Application for a Non-Material Amendment Following a Grant of Planning Permission

Erection of 2 dwellings
Holme Field Silver Street Kentisbeare Cullompton

22/00822/FULL

**306.A.12.A**

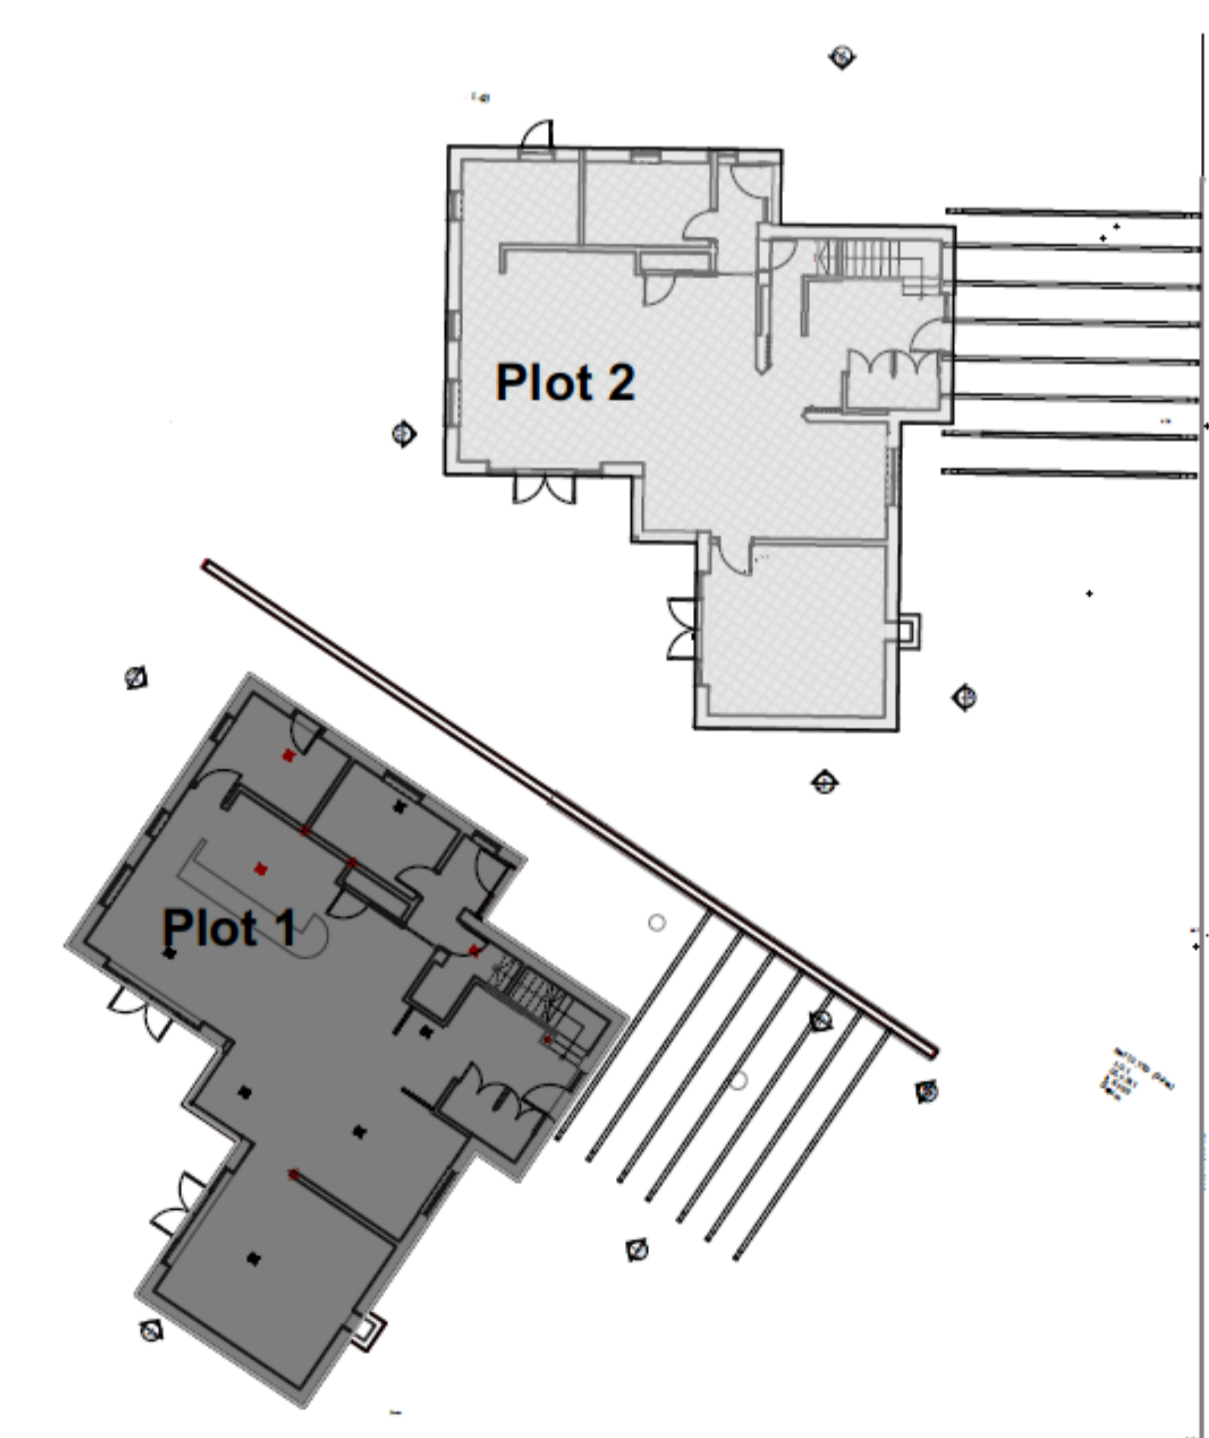
Reduce the main roof pitch from 20 to 15 degrees. Alter the fenestration and adjust window locations.
Increase the height of the secondary pitched roof by 1.4m.
Increase the number of PV panels on south facing roof.

Alterations to improve internal layout of the building partly to allow for the installation of heat recovery plant and infrastructure.
Allow the building to have sufficient PV generation; allow for the use of heat recovery units hot water generation.
Pitch to be reduced to reduce the overall visual mass of the building.
Fenestration altered to reduce overlooking of neighbours.
